WEST SUSSEX COUNTY COUNCIL CONSULTATION

TO:	Arun District Council - FAO: Hannah Kersley
FROM:	WSCC – Highways Authority
DATE:	23 June 2025
LOCATION:	Westholme Nursery Toddington Lane Littlehampton BN17 7PP
SUBJECT:	LU/83/25/OUT Outline planning application (with all matters except access reserved) for the construction of 31 No. residential units. This application is in CIL zone 2 (CIL liable) and may affect the setting of listed buildings.
RECOMMENDATION:	More Information / Modification

### Access Drawing / Visibility Splays

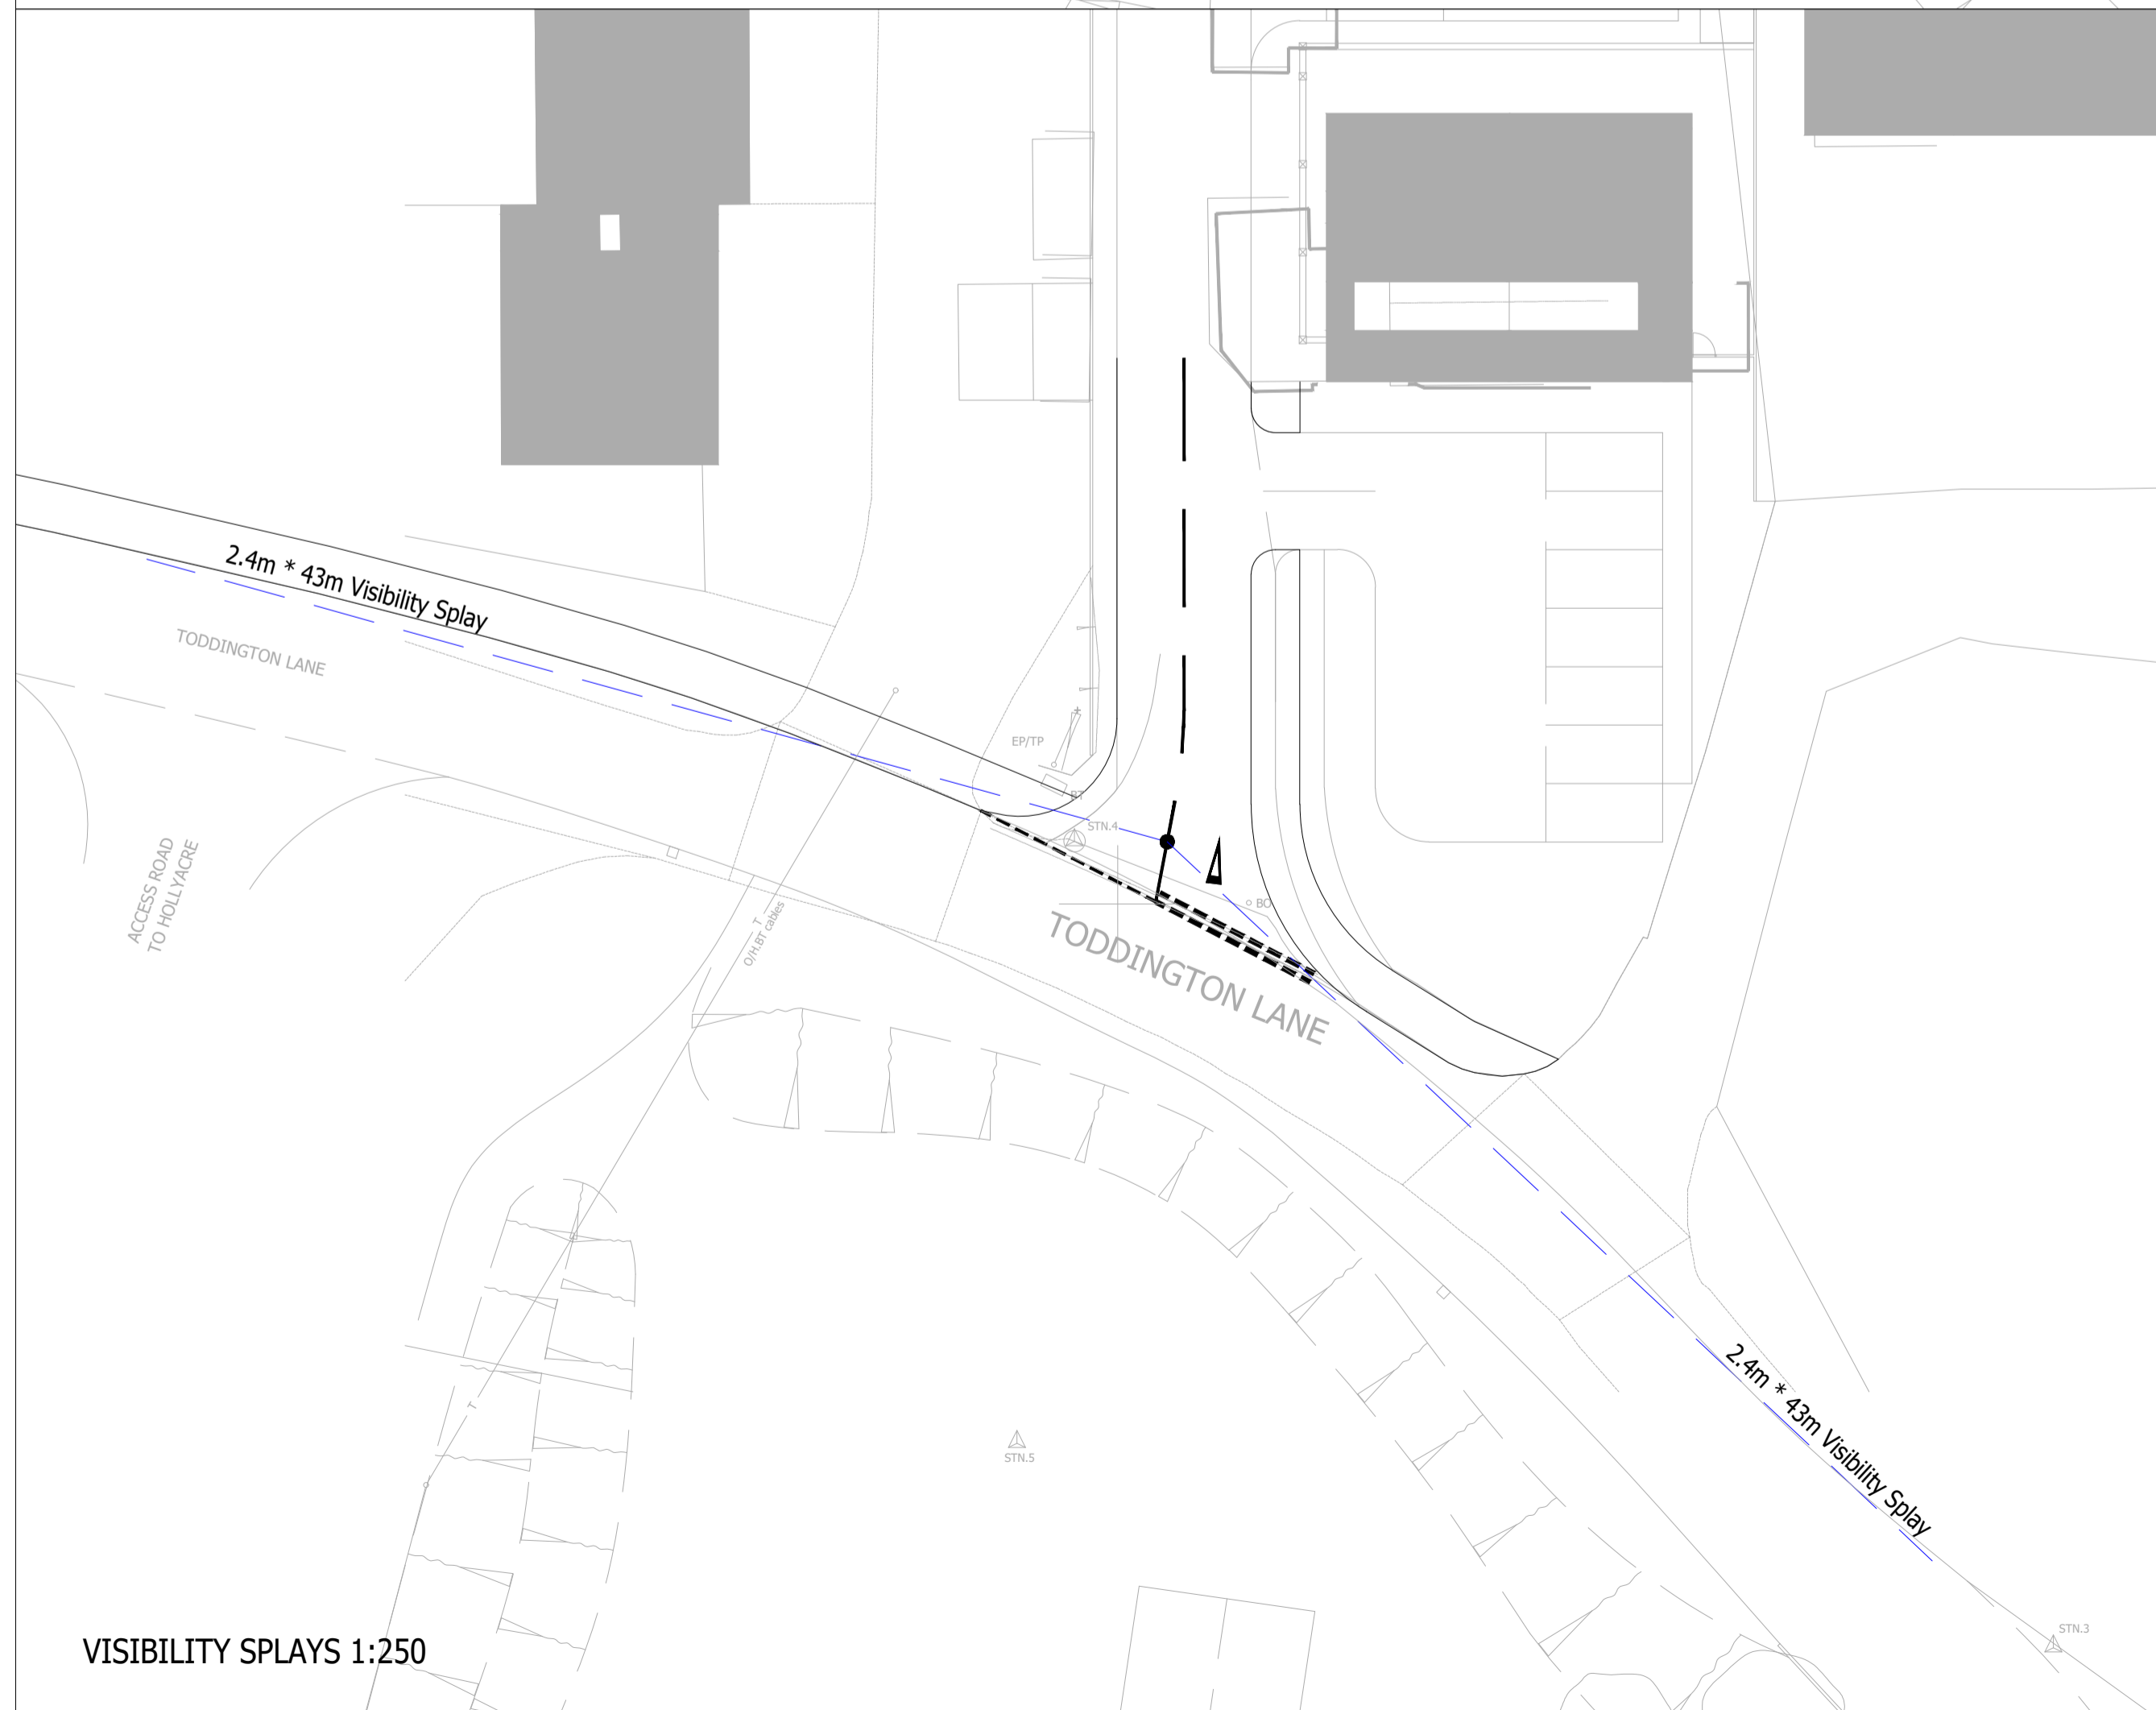
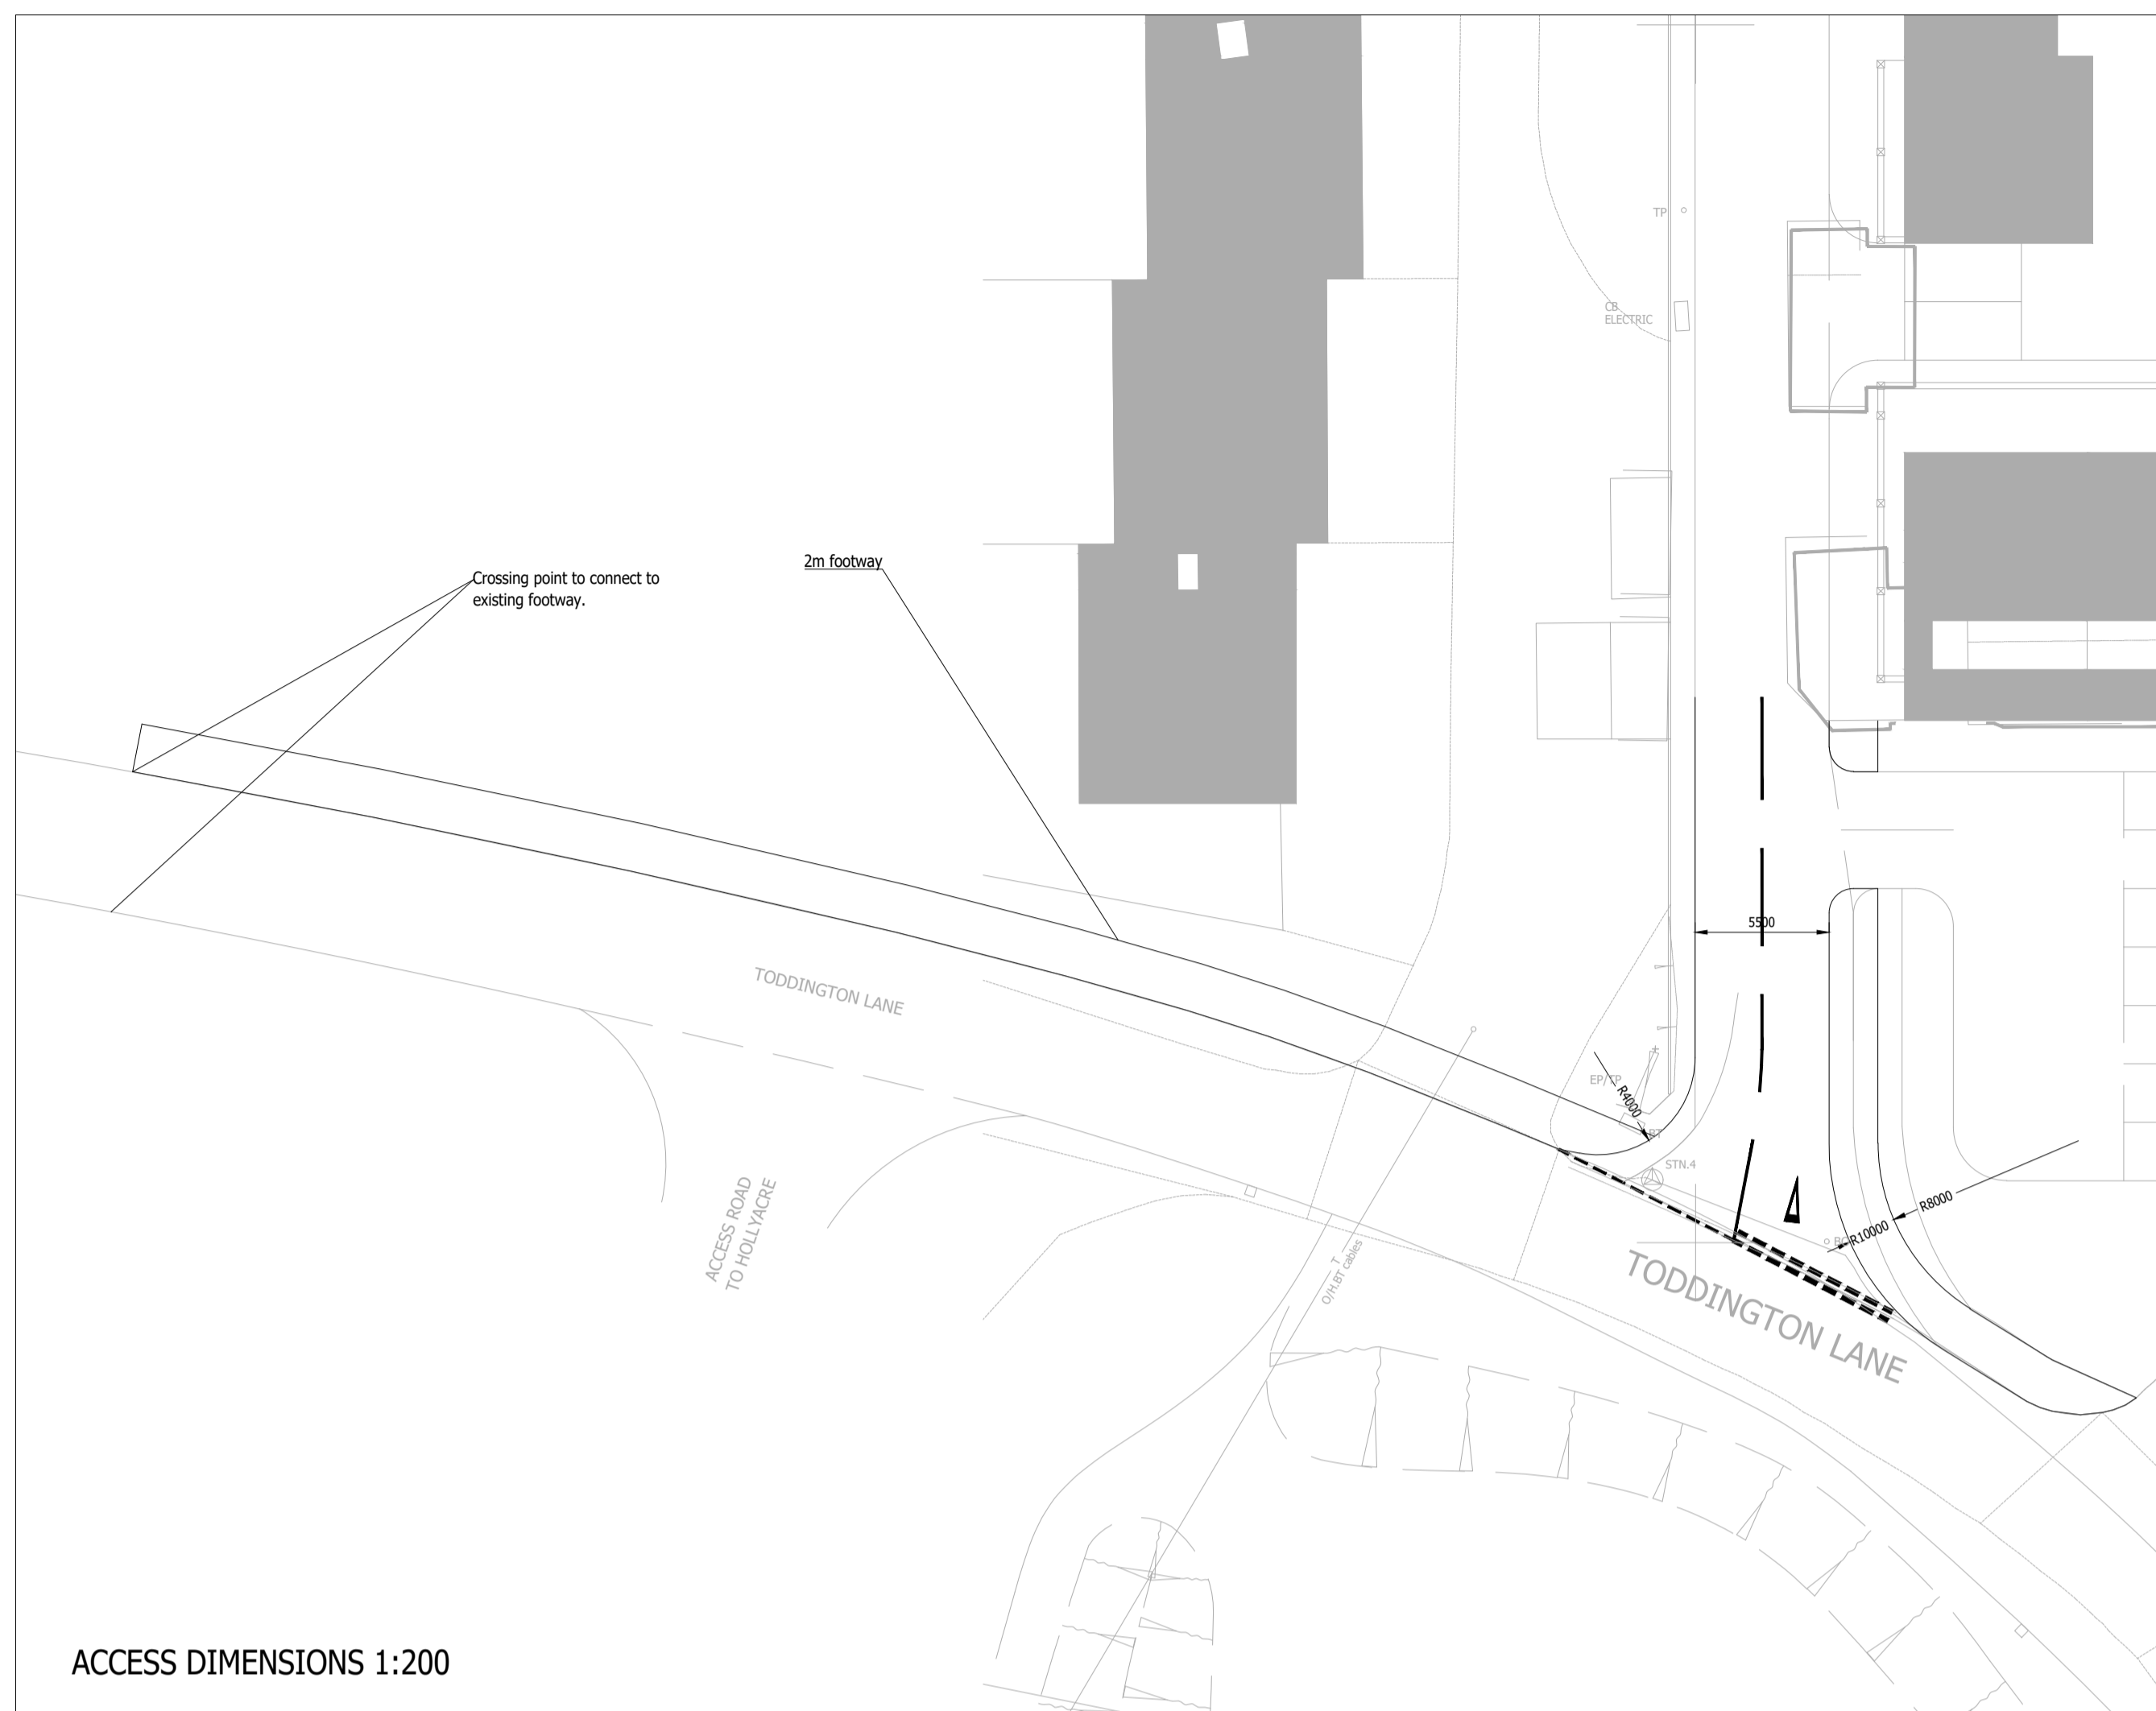
Existing access will be upgraded to bellmouth junction, existing access road will be removed. Visibility splays shown to 30mph speed restriction (2.4m x 43m). It is evident from plans and WSCC highway boundary mapping that in excess of this can be achieved within publicly adopted highway and no concerns are raised in terms of visibility for vehicle exiting the site.

Footway is proposed either side access with 2m wide footway along north side Toddington Lane to link to existing at Trevett Place. Uncontrolled crossing (dropped kerb/tactile paved) to connect to existing footway on south side of Toddington Lane. Plans do not show these crossings in detail. Also advise uncontrolled crossing of site access demonstrated.

3.1.1 – lack of footway continuity – raised that strategic footway design should be incorporated and designer agreed, noting 60m connecting footway is proposed adj. Trevett Place. Reviewing the RSA it would appear this issue specifically relates to the section of footway around the site access (east side) in terms of this not connecting in to anything. Whilst LHA acknowledge the linking footway west of site, we consider that provision of dropped kerb/tactile paved crossing of site access would help link footway connection from within site/east side of access to the new proposed footway linking to Trevett Place.

- Show the uncontrolled dropped kerb/tactile paved crossing of Toddington Lane and connection in
- Show dropped kerb/tactile paved crossing of site bellmouth access
- Provide Designers Response
